# TRAFFIC IMPACT ASSESSMENT (TIA)

**Proposed Waste Management facility  
2-4 Hale Street, Botany**

Reference: 23.464r01v13  
Date: March 2025

This revised TIA has been prepared to accompany an amended SSD application to address comments concerning the proposal from Department of Planning, Housing and Infrastructure (DPHI) as contained in a letter dated 13 September 2024 (DPHI Reference: SSD-62855708), and Bayside Council as contained in a letter dated 9 September 2024 (Council Reference: SSD-2024/10).

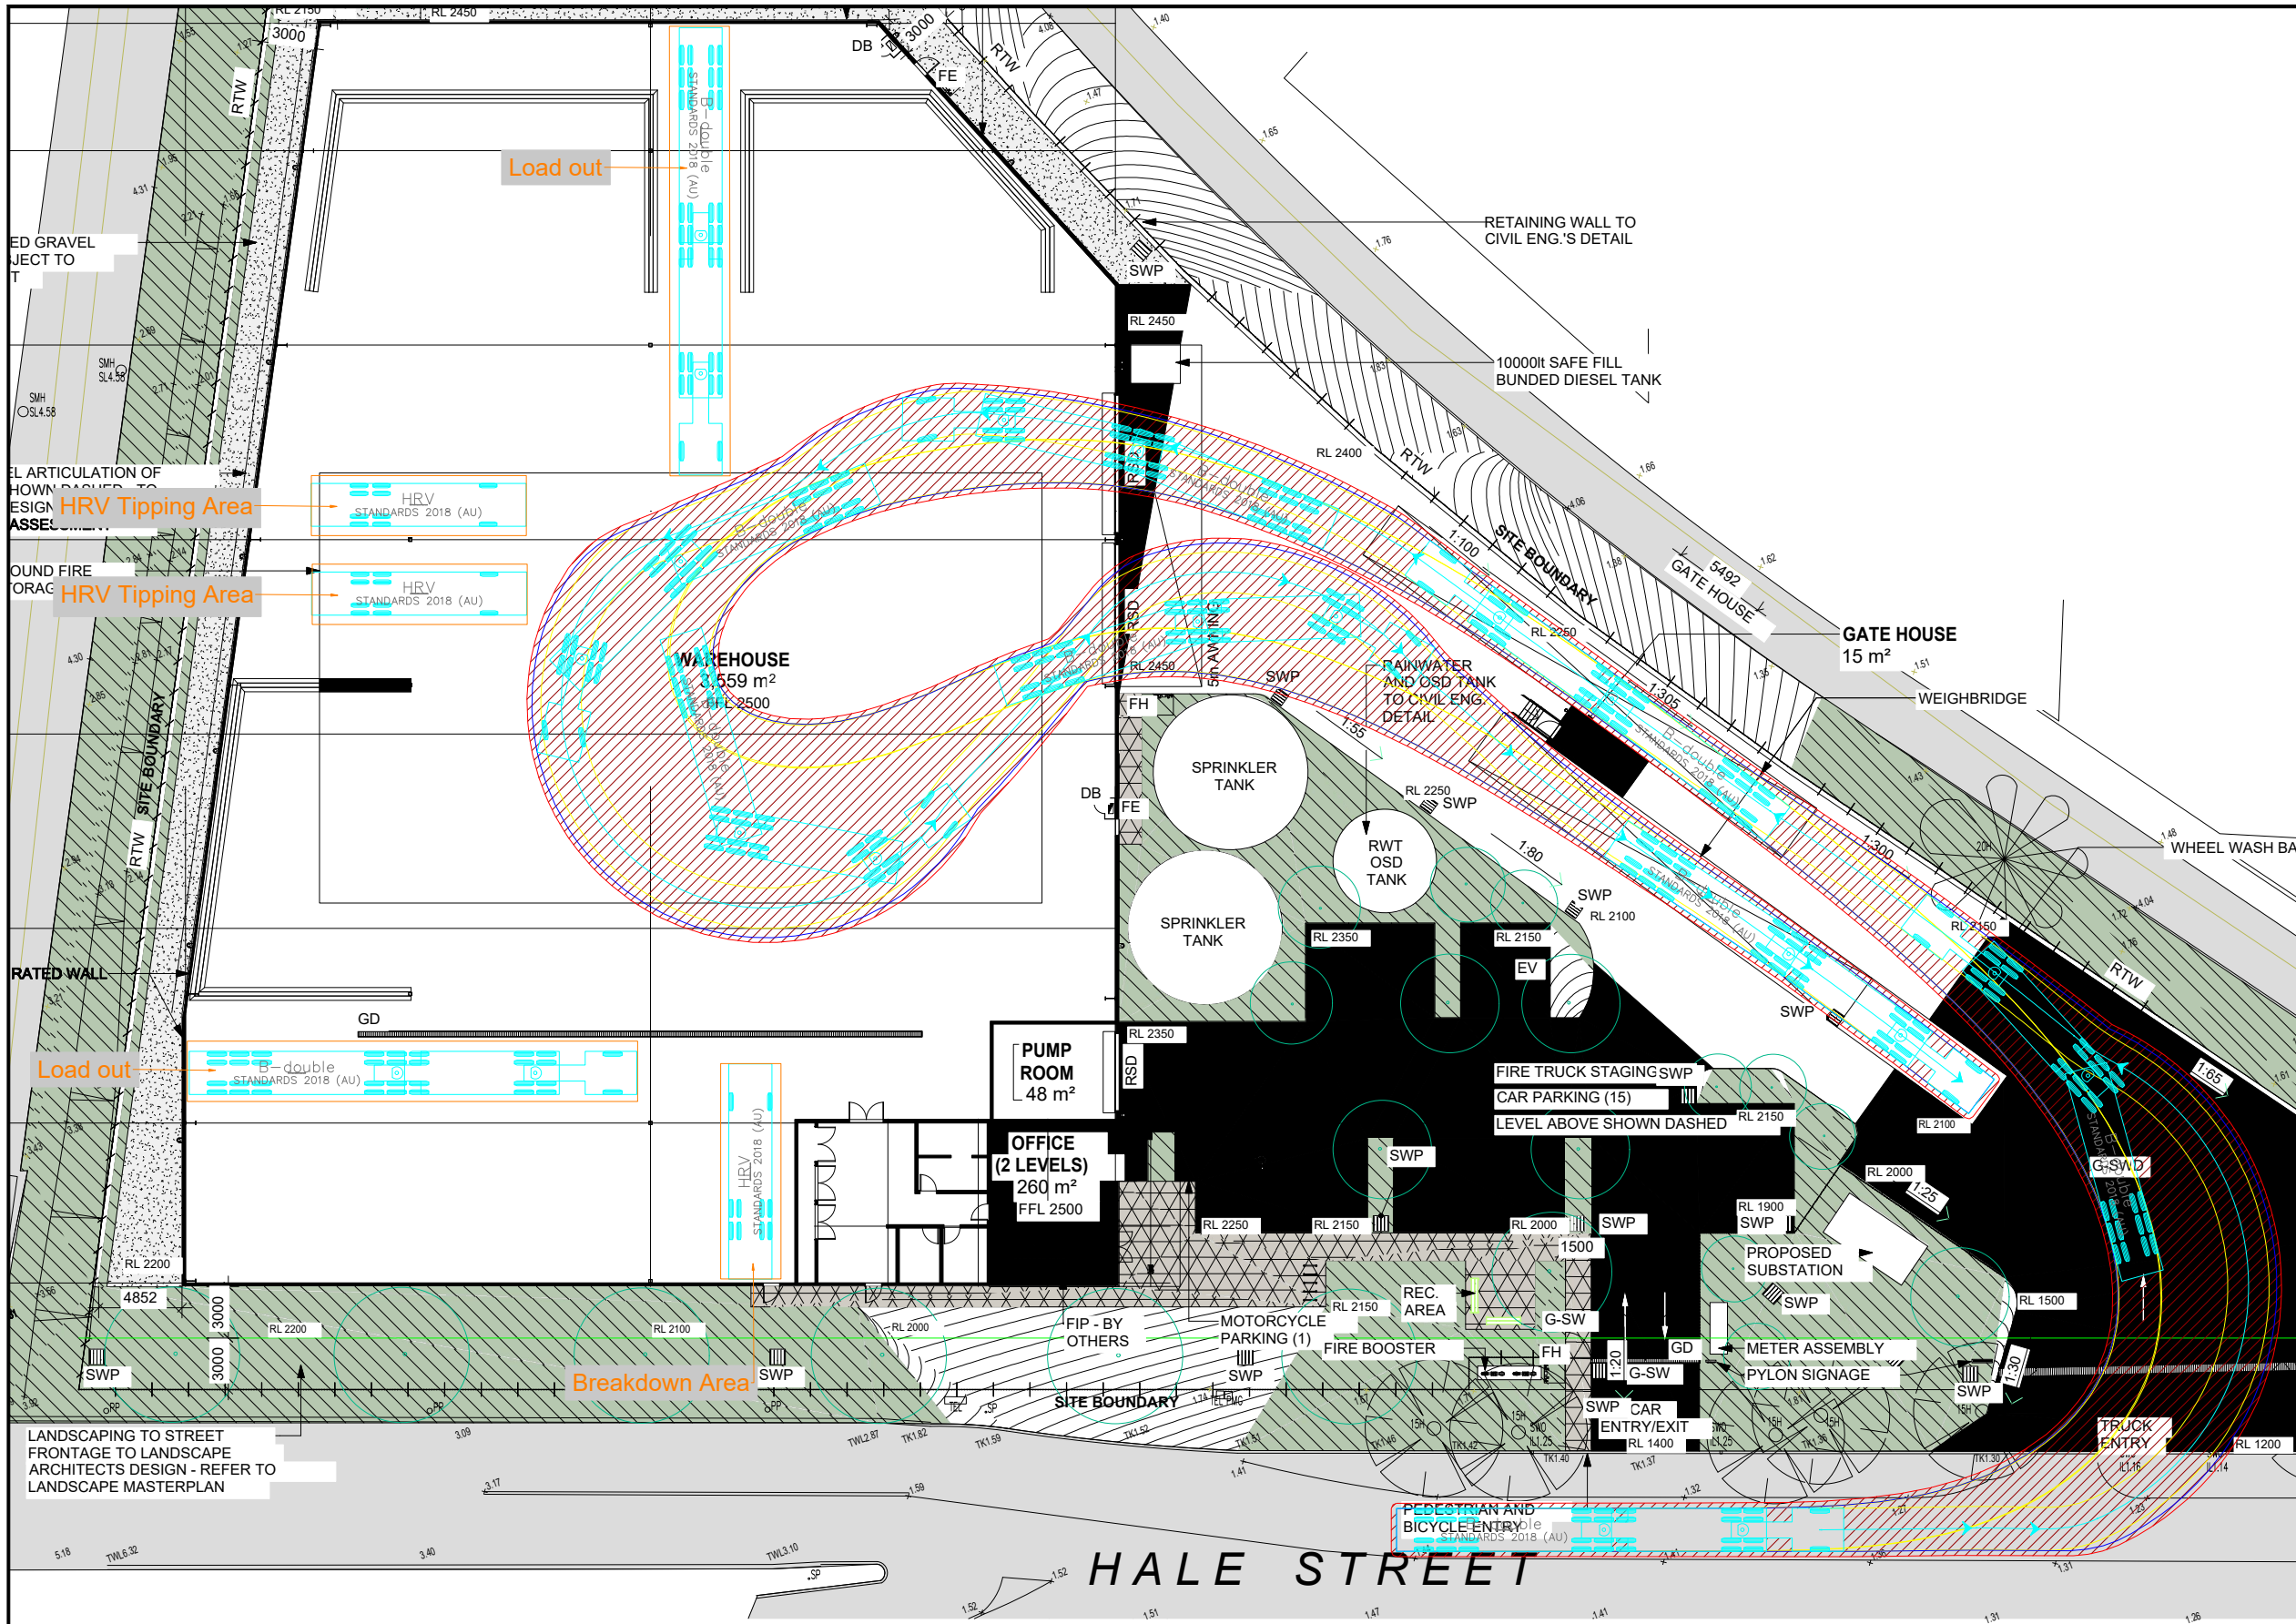
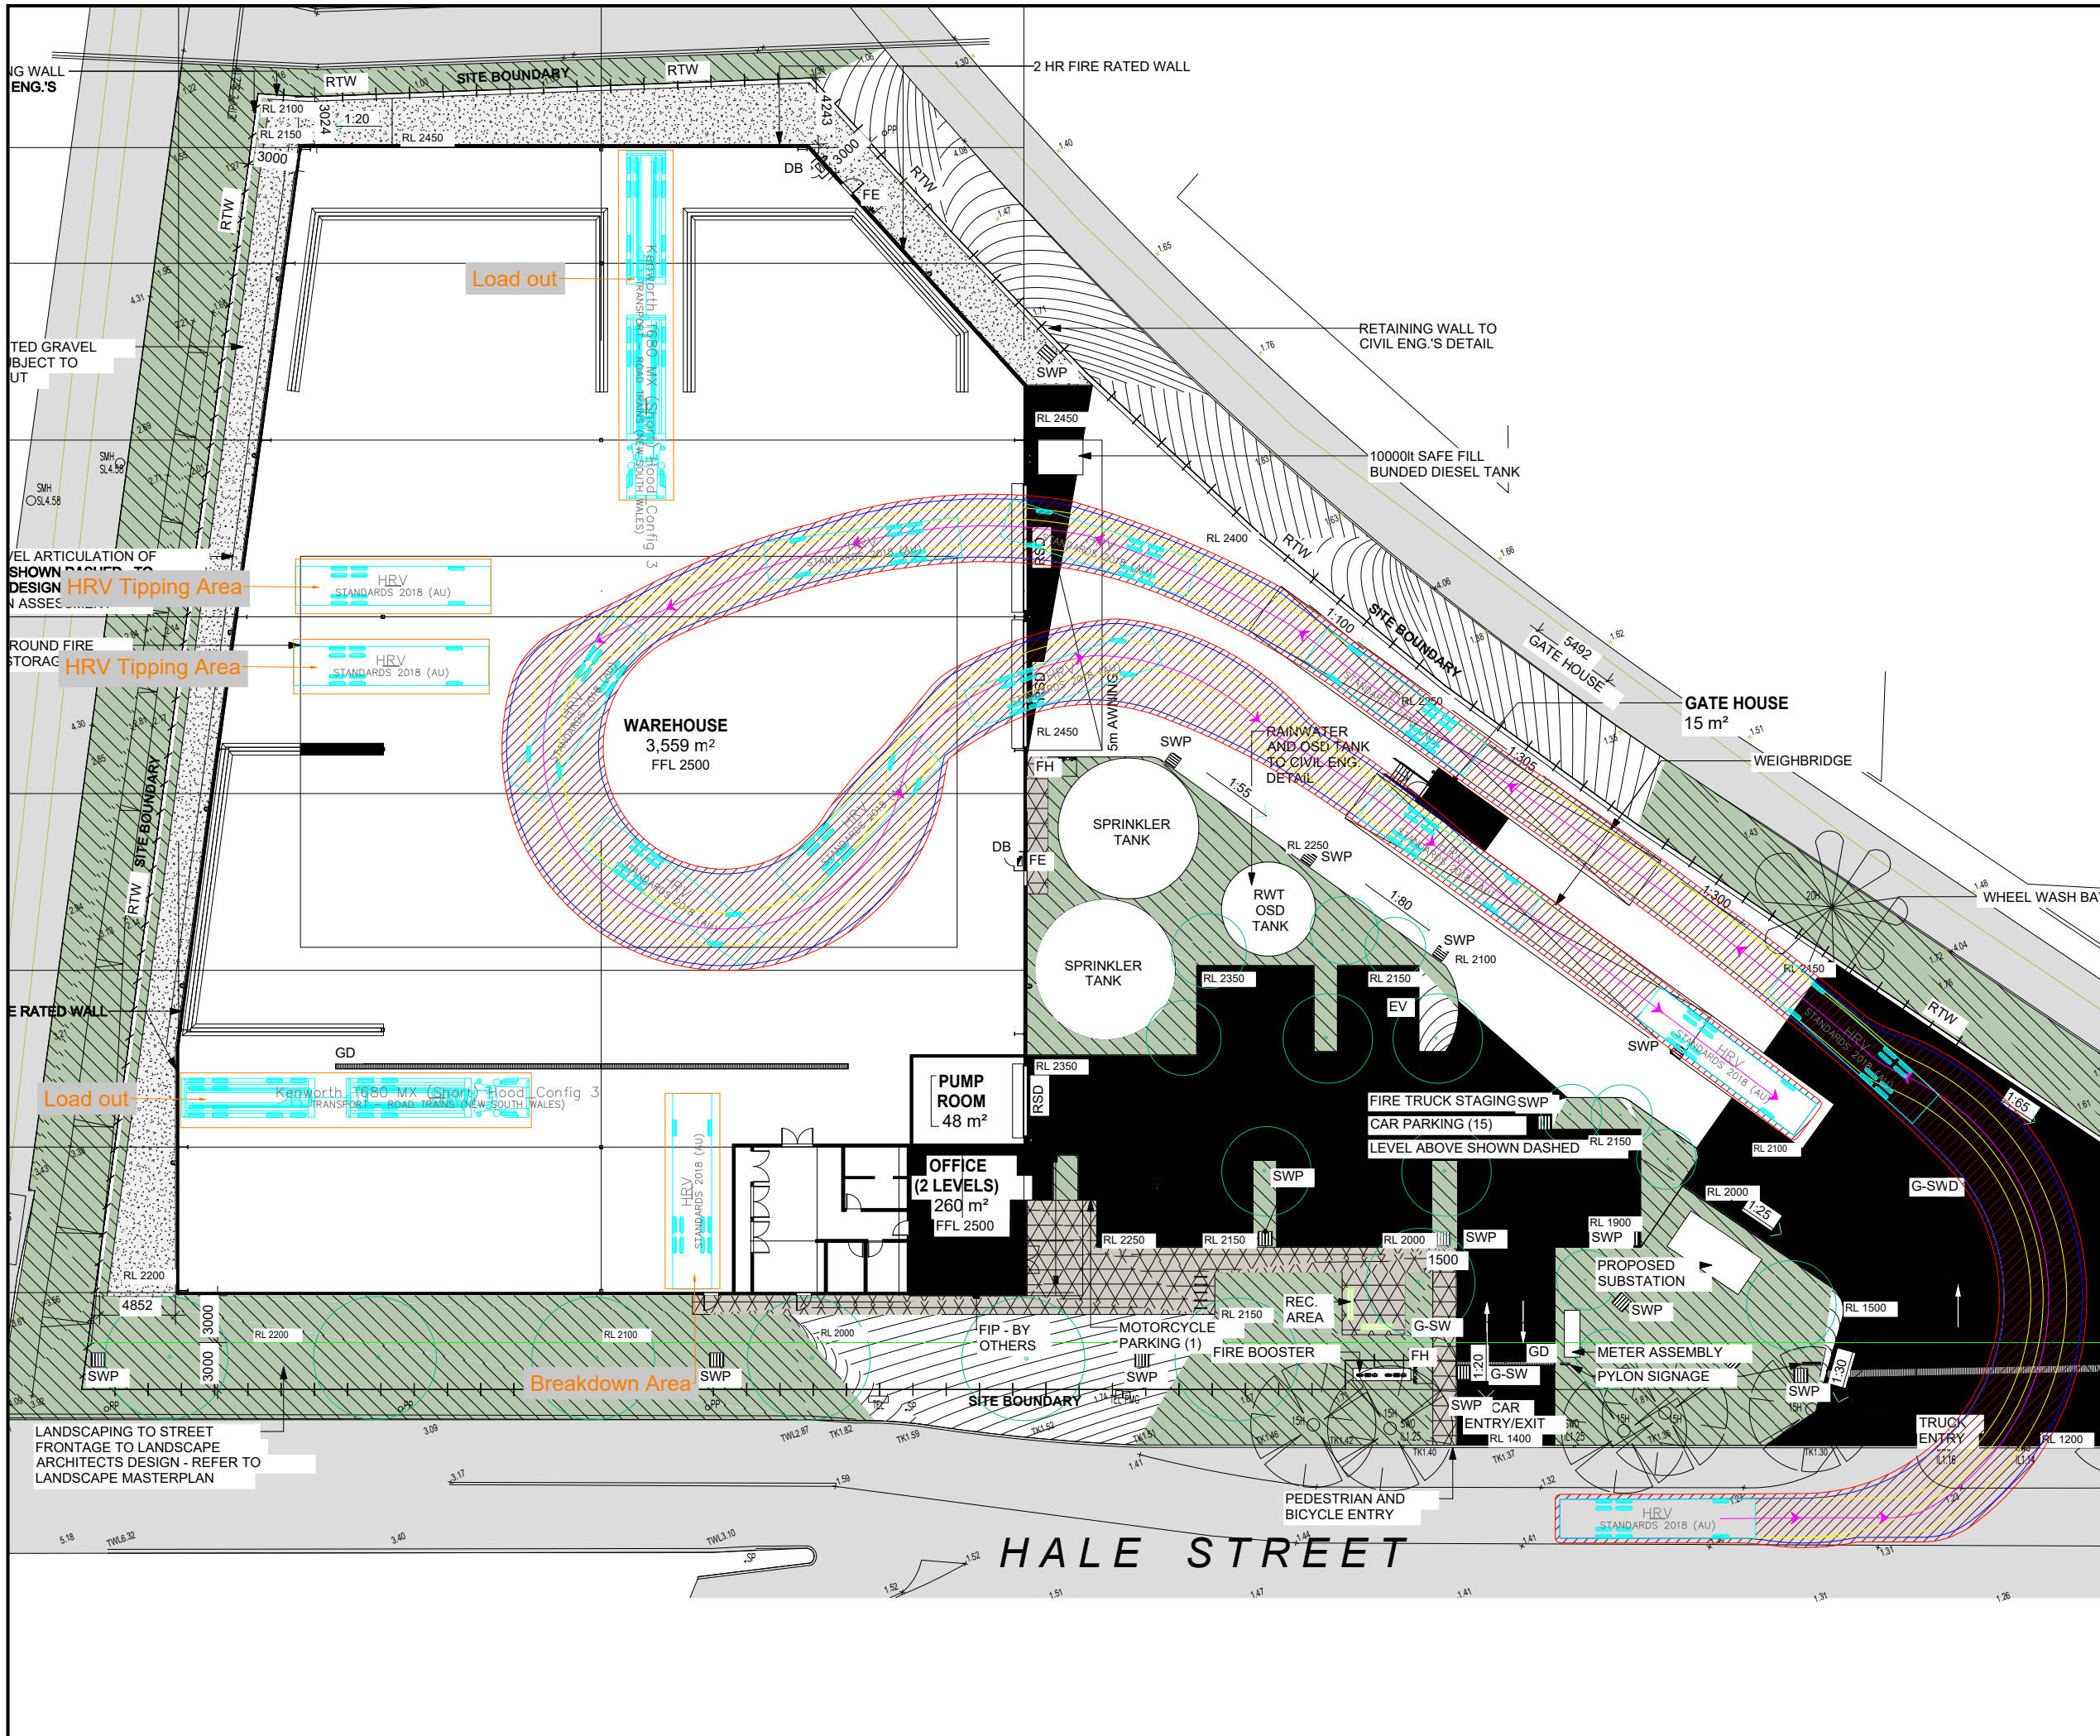
<p><b><u>Swept Path Analysis</u></b></p> <p>The swept path analysis for the site access driveway provided at Appendix D of the TIA is unclear and indicates there may be conflict between two B-doubles travelling eastbound and westbound on Hale Street.</p> <p><b>Recommendation: Revised swept path analyses are required for 20 metre articulated vehicles and B-doubles accessing the site that clearly demonstrates the centreline of Hale Street will not be crossed and there will be no conflict with on-street parking. All line marking on Hale Street must be clearly marked.</b></p>	<ul style="list-style-type: none"> <li>• Swept path analysis have been updated with recent Nearmap aerial georeferenced in the background clearly demonstrating 26m B-double vehicles will be able to ingress and egress the site satisfactorily in accordance with AS 2890.2 (2018).</li> </ul>
<p><b><u>Daily Heavy Vehicle (HV) Movements</u></b></p> <p>Section 6.10: Truck Frequencies of the TIA outlines the anticipated truck volumes for the development. It is not clear how these vehicle numbers have been determined. Bayside Council has also raised several queries regarding the traffic generation analysis.</p> <p><b>Recommendation: Additional information is required to justify the predicted truck volumes, including the breakdown of vehicle types.</b></p>	<ul style="list-style-type: none"> <li>• TIA has been updated to provide detailed calculations on how the anticipated heavy vehicle trip generation associated with the proposed development has been estimated including a breakdown of the vehicle types, refer to <b>Section 9</b>.</li> </ul>

<p>The appendix D swept path analysis details an unrealistic kink in the truck wheel movement near the car entry/exit. See figure below.</p>	<ul style="list-style-type: none"> <li>All swept path analysis has been undertaken using the latest version of the industry leading software AutoTURN Pro, we can provide animated swept paths in a video file or live demonstration to Council upon request to prove our professional integrity.</li> </ul>
<p>The swept path analysis shall be revised to better depict all line marking on Hale Street. Vehicles shall not cross over the road centreline.</p>	<ul style="list-style-type: none"> <li>Swept path analysis have been updated with recent Nearmap aerial georeferenced in the background clearly demonstrating 26m B-double vehicles will be able to ingress and egress the site satisfactorily in accordance with AS 2890.2 (2018).</li> </ul>
<p>The parking rate derived in section 7 of the traffic report is insufficient for this site. 1 car parking space shall be provided for each staff member in addition to the 4 visitor spaces. Additionally, given the swept paths and the two driveways proposed, the on- street parking on the northern side of Hale Street is effectively entirely removed by this development. The loss of public parking needs to be supplemented by the development.</p>	<ul style="list-style-type: none"> <li>The proposed development has been amended to provide a minimum of one (1) car parking space per FTE staff in addition to the four (4) visitor spaces in accordance with Council's request.</li> <li>It is unclear how on-street parking can be supplemented by a private development that is not open to the public notwithstanding the security and legal challenges if this was permitted to occur.</li> <li>Refer to <b>Section 8.6</b> of this report.</li> </ul>
